Our ref: HA/2011/111266/01-L01

Date: 17 February 2011

**OUTLINE APPLICATION WITH SOME MATTERS RESERVED FOR THE
DEMOLITION OF DERELICT 2 STOREY OFFICE BUILDING & ERECTION OF 8
NO. 2 BED FLATS & 6 NO. 1 BED FLATS WITH GROUND FLOOR PARKING,
BIN & CYCLE STORAGE & CHILDRENS PLAY AREA
FORMERLY WESTSIDE SUPPLIES 17/18 DURBAN ROAD BOGNOR REGIS**

DRAWING
Site Location, Block & Layout
Plans with Proposed Front
Elevation to Durban Road

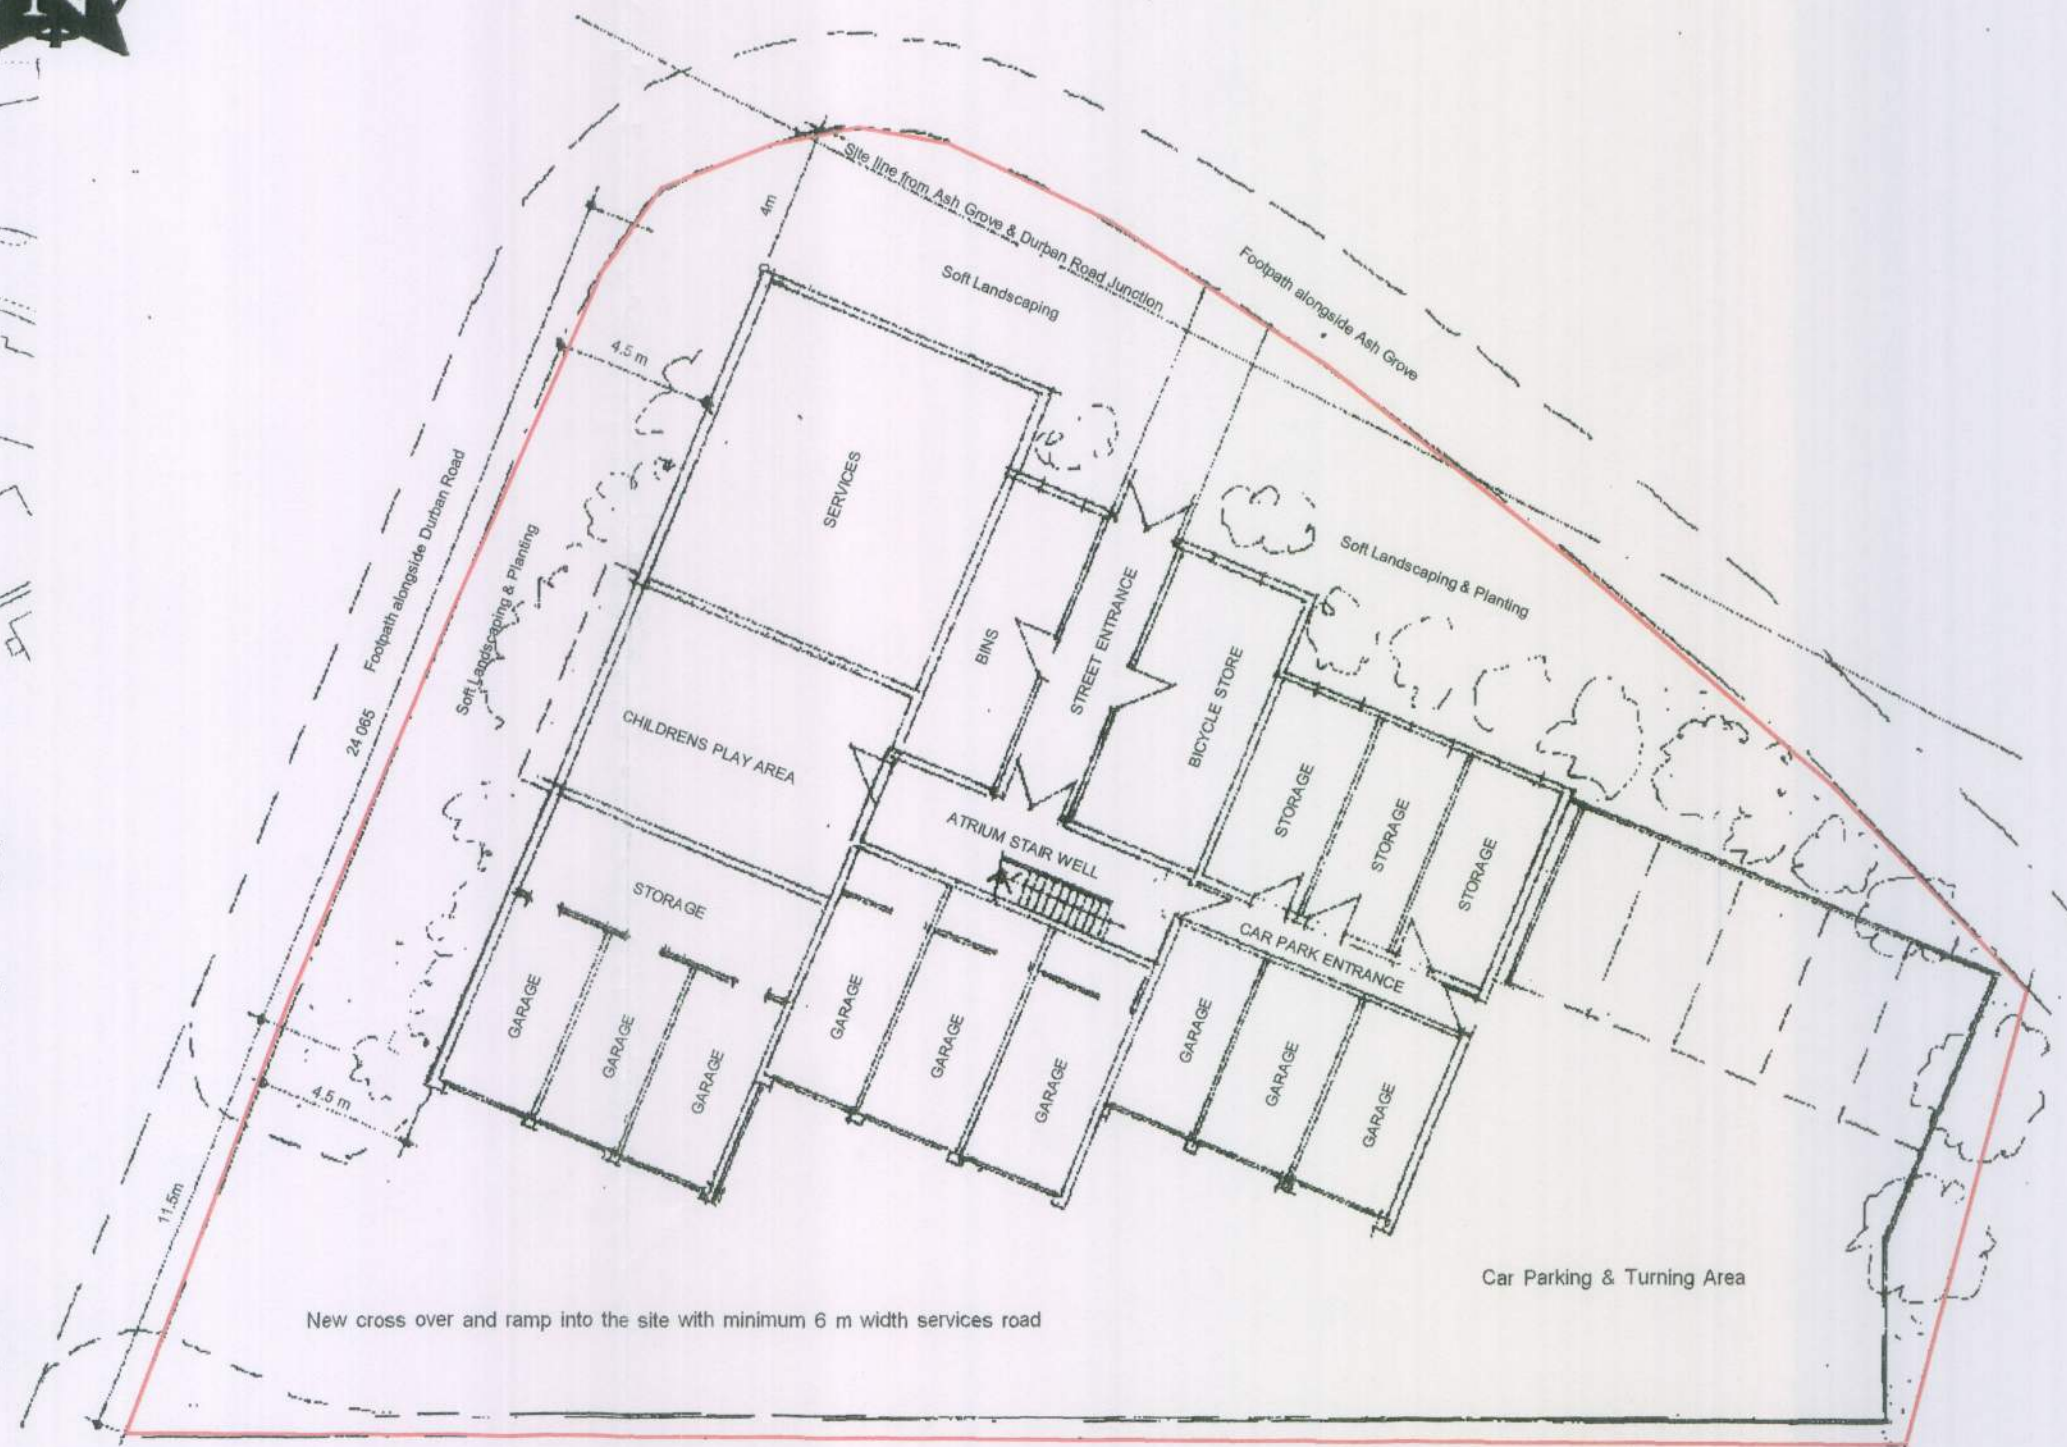
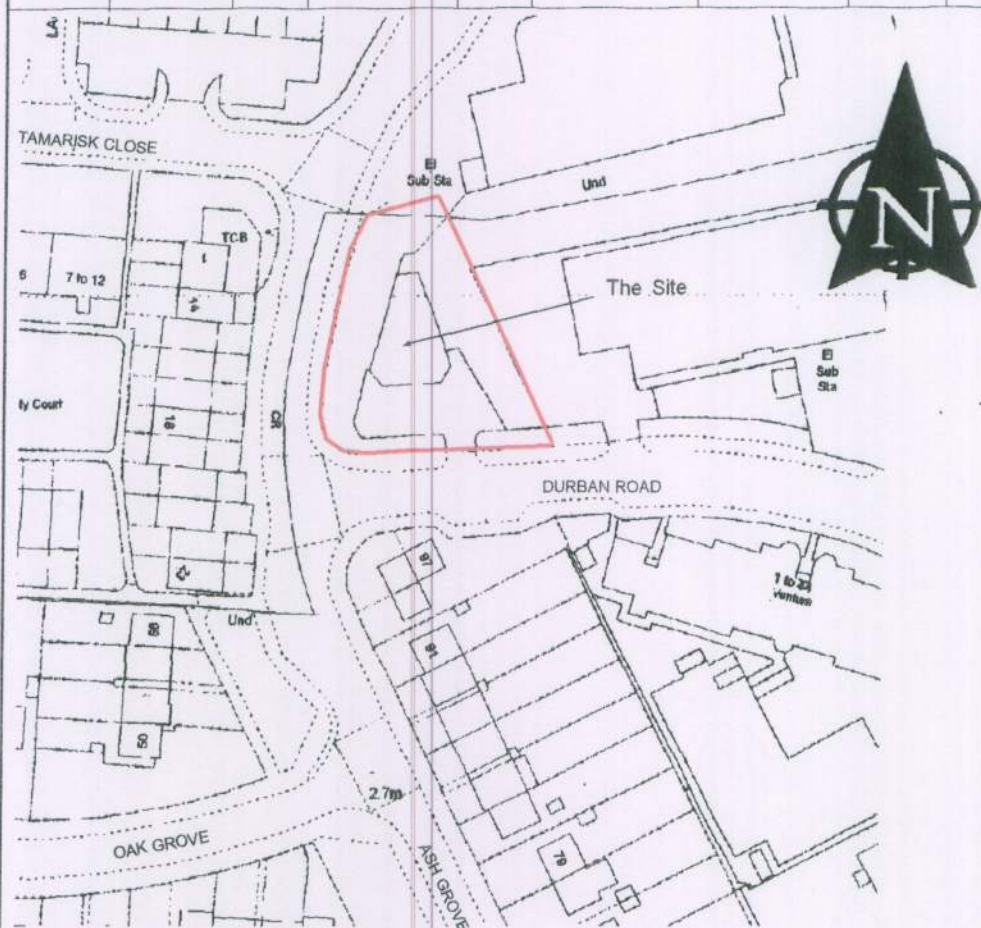
The development permitted by this planning permission shall only be carried out in accordance with the approved Flood Risk Assessment (FRA) and the following mitigation measures detailed within the FRA:

1. Finished floor levels are set no lower than 2.2 m above Ordnance Datum (AOD).

Please note that there may be a culverted watercourse either within or adjoining the site. The applicant should ensure that the development is not located above any culvert. If it is necessary to divert the culvert, then Flood Defence Consent would be required from the Environment Agency under the Land Drainage Act, 1991.

All surface water from roofs should be piped direct to an approved surface water system using sealed down pipes. Open gullies should not be used.
